TfNSW reference: REN25/00086/002

Your reference: SSD-72430958

**SSD-72430958, Finley Battery Energy Storage System - Various Lots, Berrigan Shire Council;
Response to Environmental Impact Statement**

TfNSW has reviewed the Environmental Impact Statement (EIS) prepared by Premise dated 7 May 2025 and the Traffic Impact Assessment (TIA) prepared by Premise dated 2 May 2025, as key documents for preparing this response.

Pinch Point

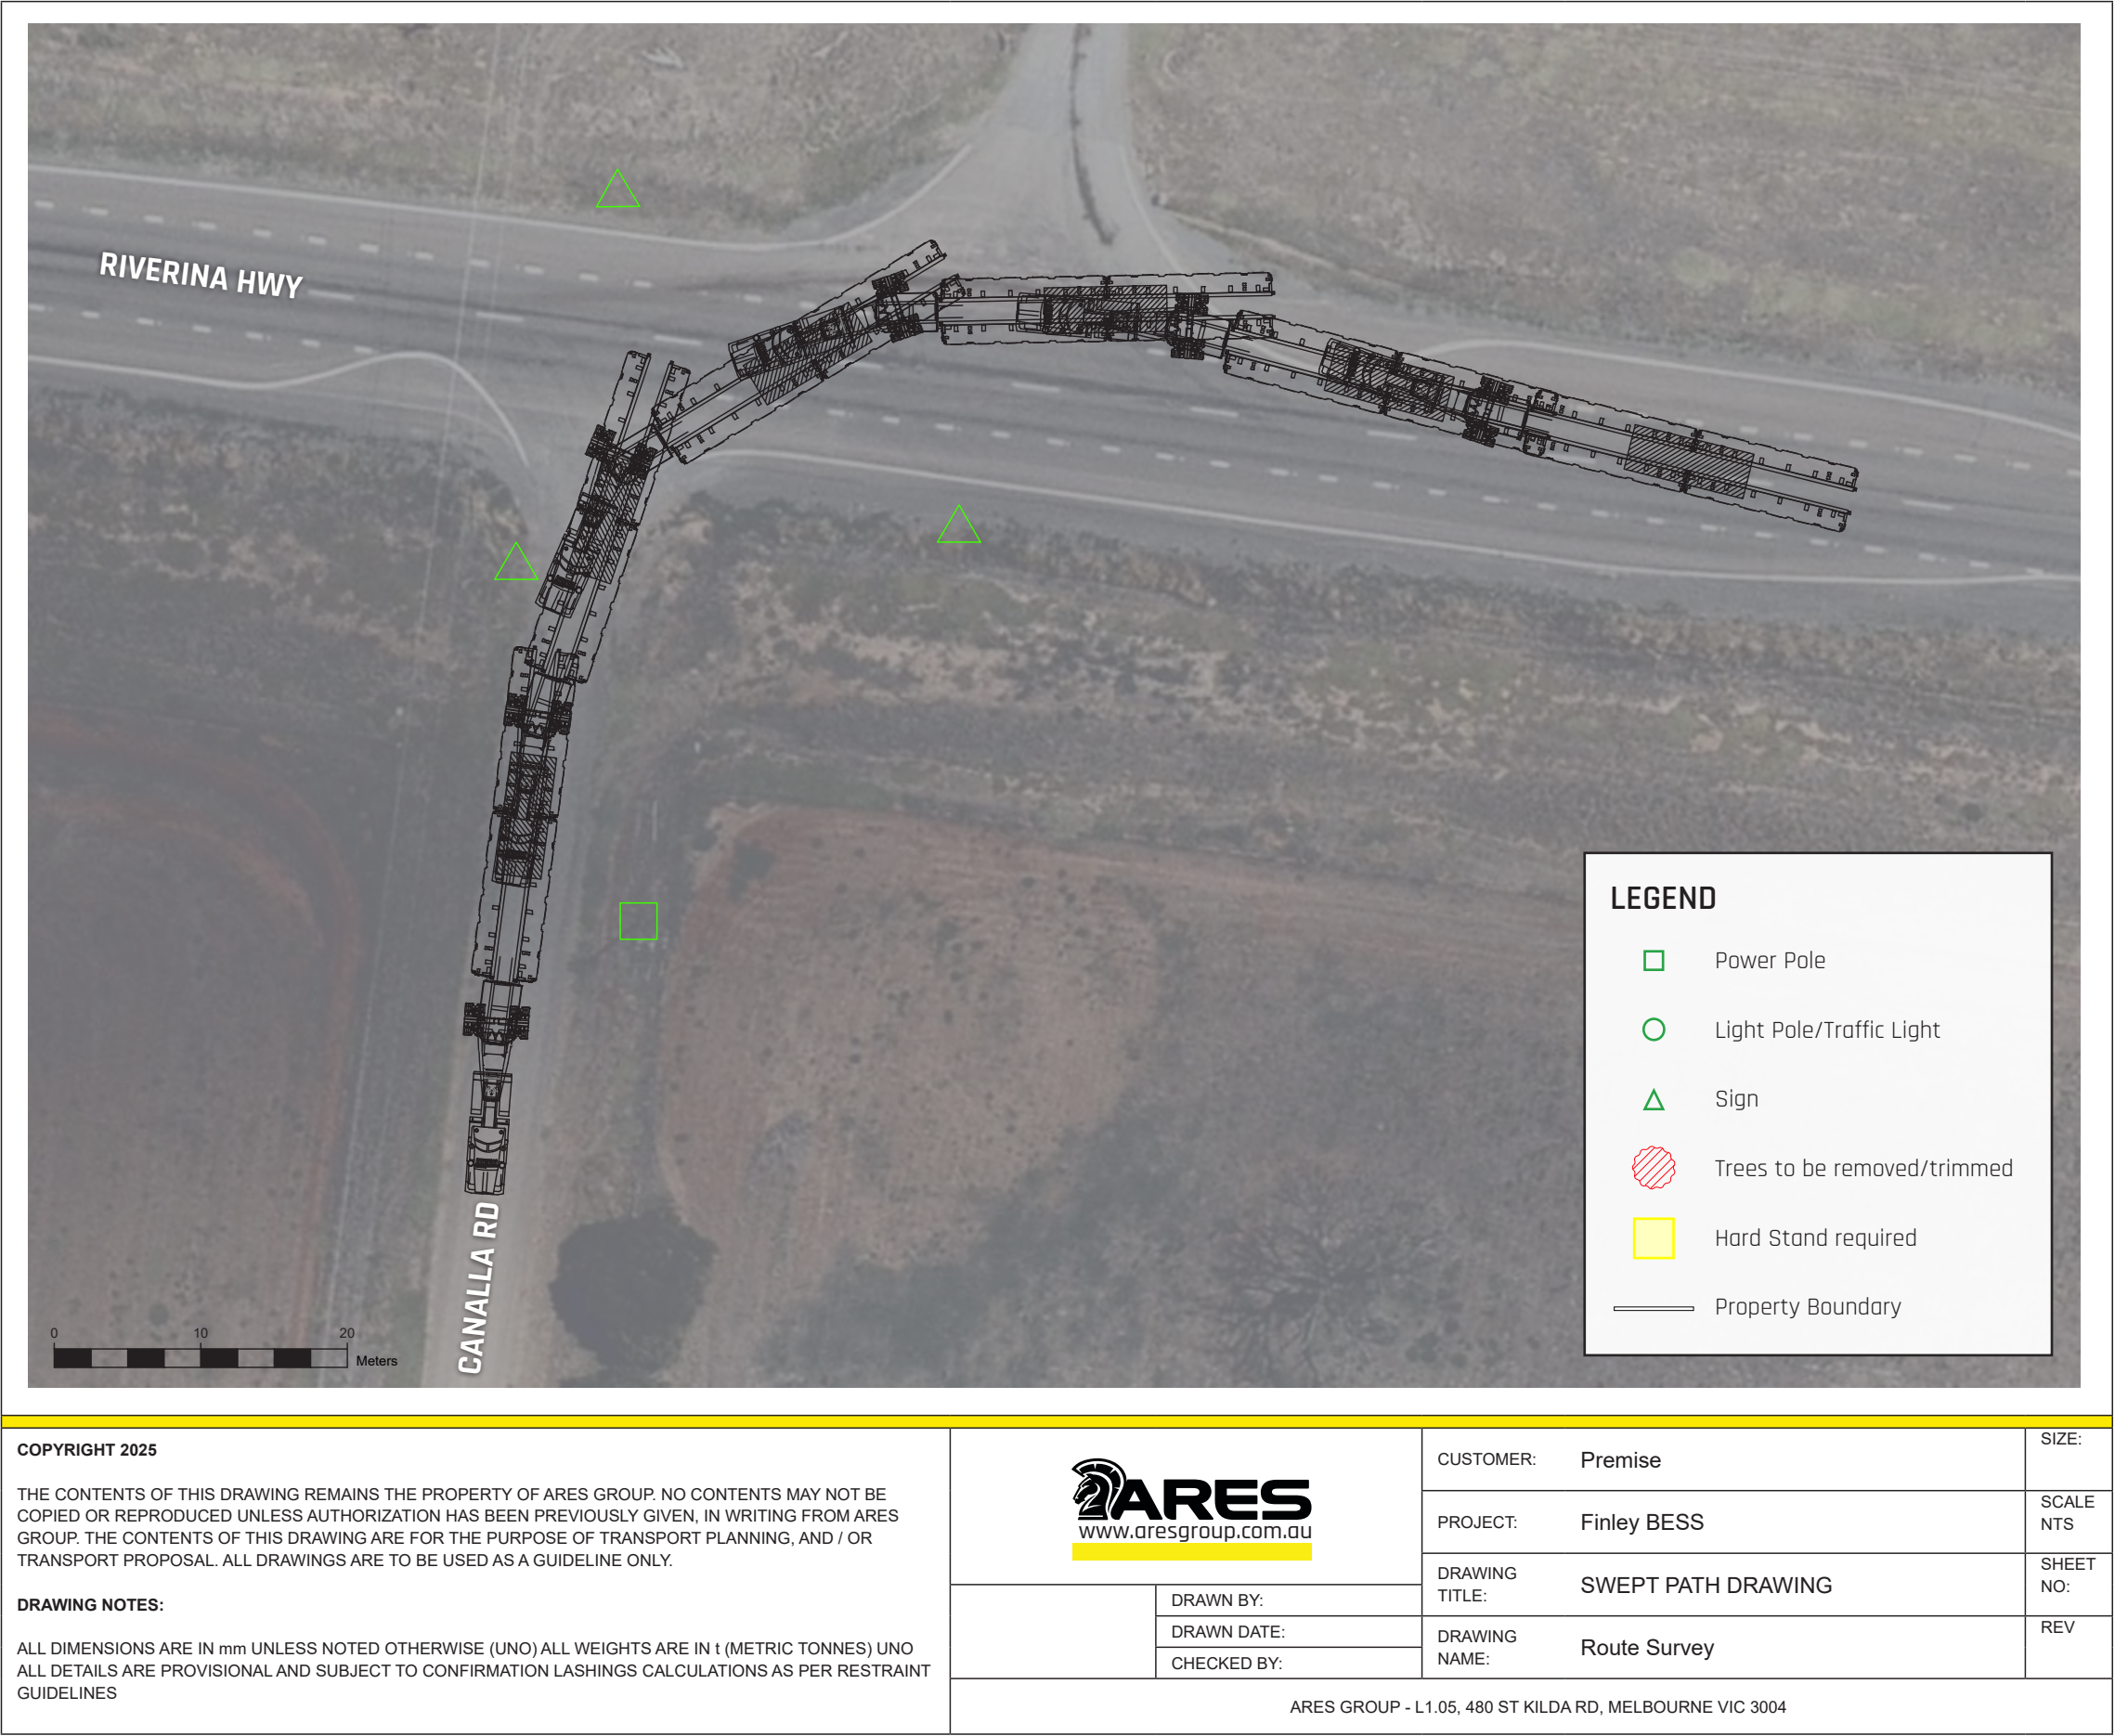
- iv. Pinch point 17 demonstrates that to make the turn into Canalla Road from the Riverina Highway, the high-risk OSOM will be entering into the opposing lanes. This will require traffic to be stopped; however, sufficient detail on how this will occur is not provided. The updated information will need to clarify how long traffic will be stopped (TfNSW notes traffic cannot be stopped for more than 10 minutes). Please include this detail in the updated TIA and ensure any other locations where traffic is required to be stopped are provided.

Rest Stops

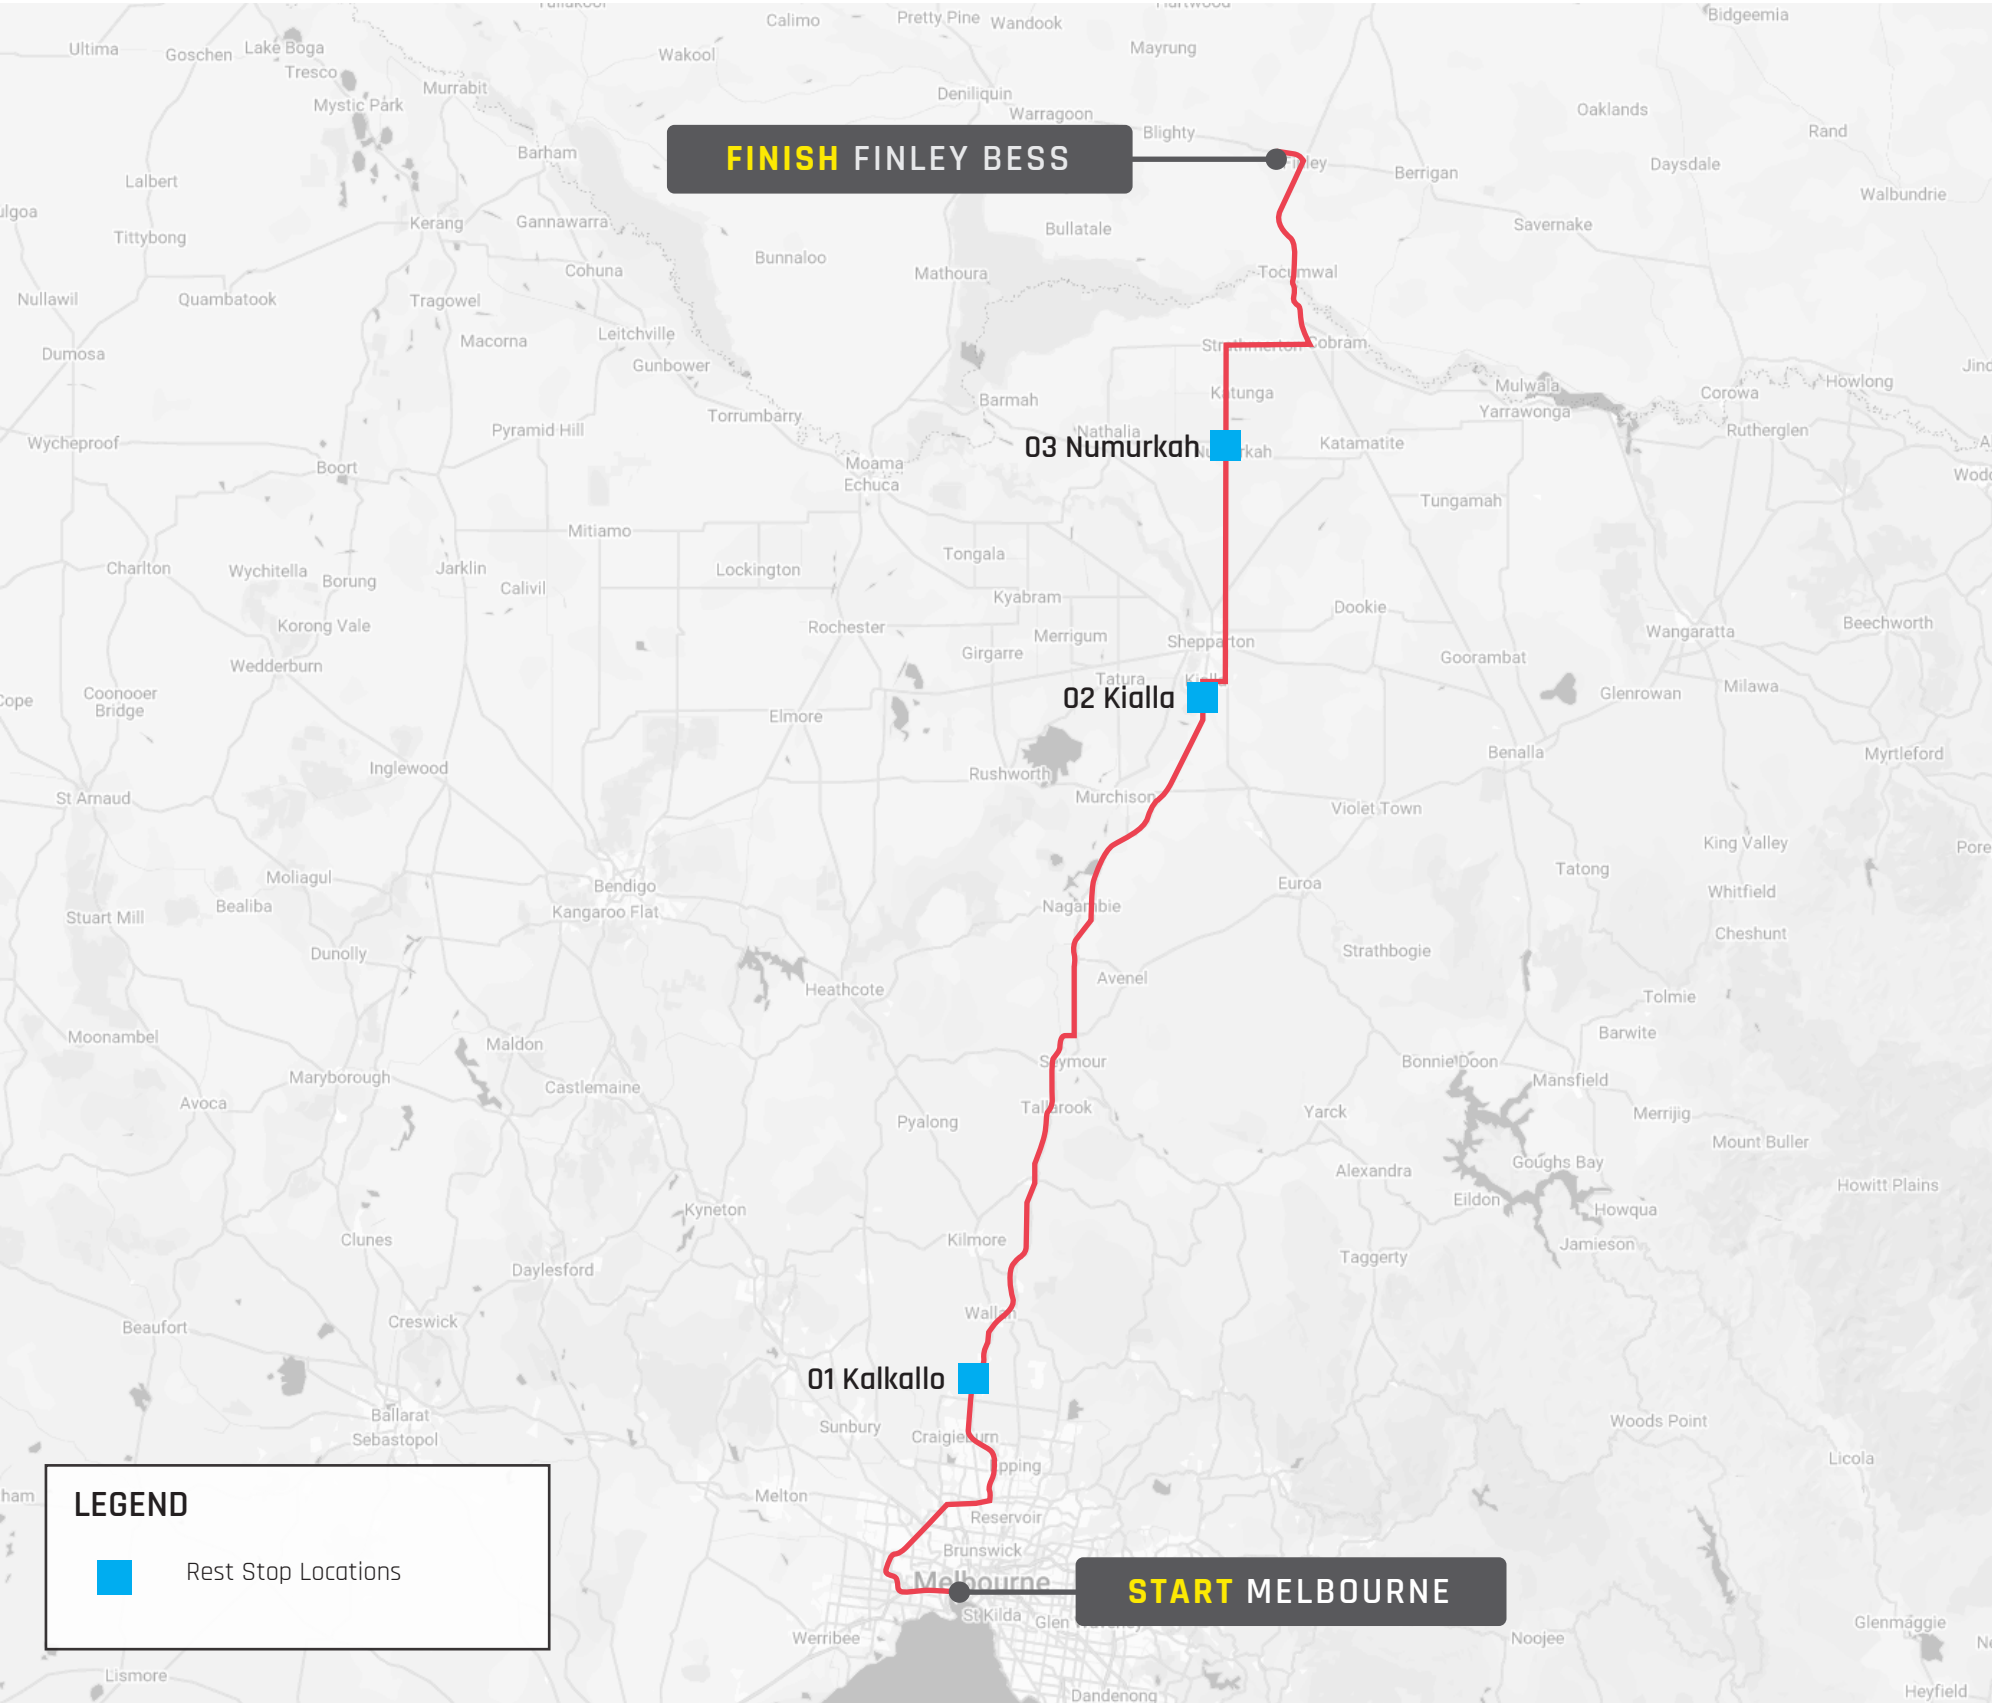
- xi. The pull-over bays and rest areas have been identified with swept paths; however, the diagrams provided aren't fully dimensioned as required. See advisory note 1 and 5.
